Eastergate Parish Council
Mr GR Sleet
9 Hedgeway
Bognor Regis
West Sussex
PO22 7QY

Your Ref: OWPC15800
Our Ref: EG/69/17/PL
Please ask for:
Mr S Davis

4 No. live/work units, Research & Development propagation building & growing area, garden room, fuel store & greenhouse to main dwelling & formation of new access. This application is a Departure from the Development Plan.
Swallowfield Eastergate Lane Eastergate

Thank you for your internet comments made on 11th October 2017 which has been recorded as **'an objection'** with the comments as follows:

Fire Tender	7.334m
Overall Length	2.280m
Overall Width	3.495m
Overall Body Height	0.380m
Min Body Ground Clearance	2.280m
Track Width	5.00s
Lock-to-lock time	6.000m
Curb to Curb Turning Radius

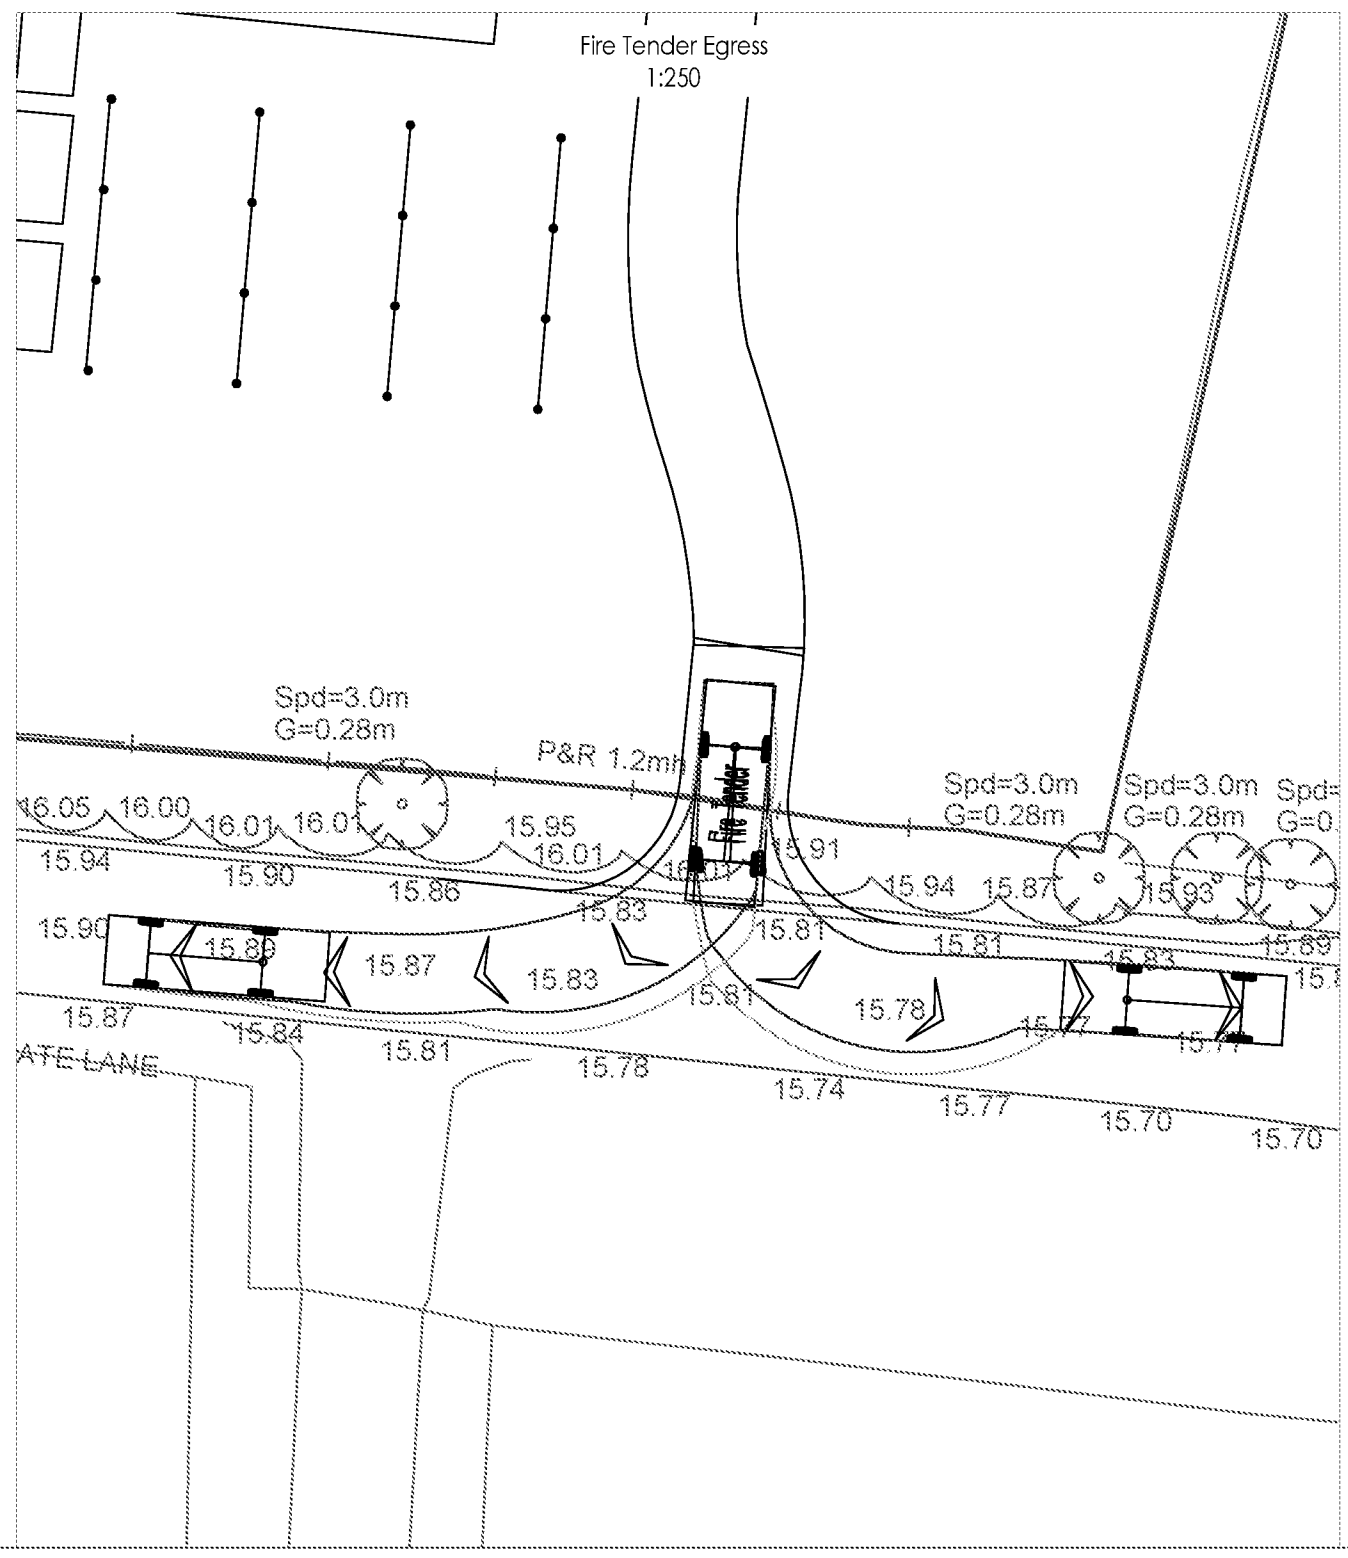
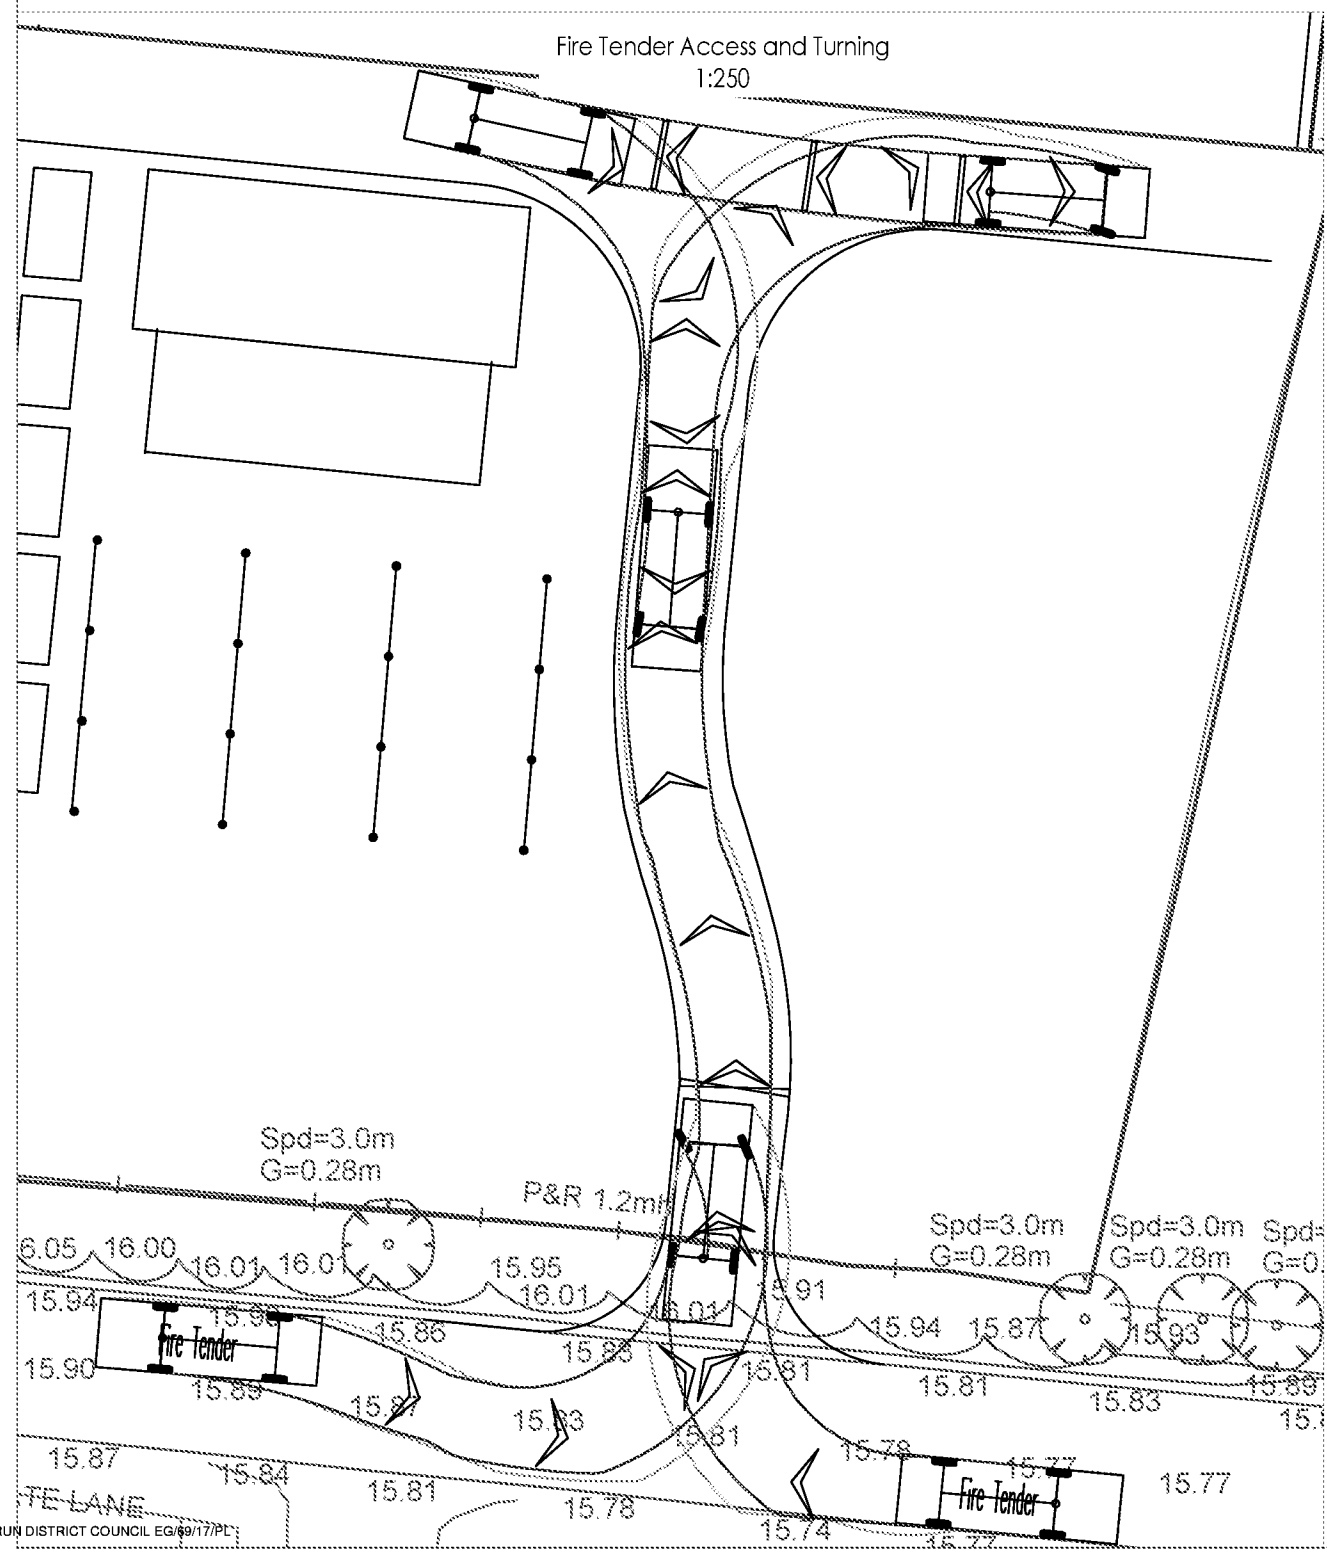
The council considers that the application should not be permitted without an allocation of space, on site, for articulated and other vehicles to turn. A condition requiring the use of such turning space should, if possible, be added to any permission.
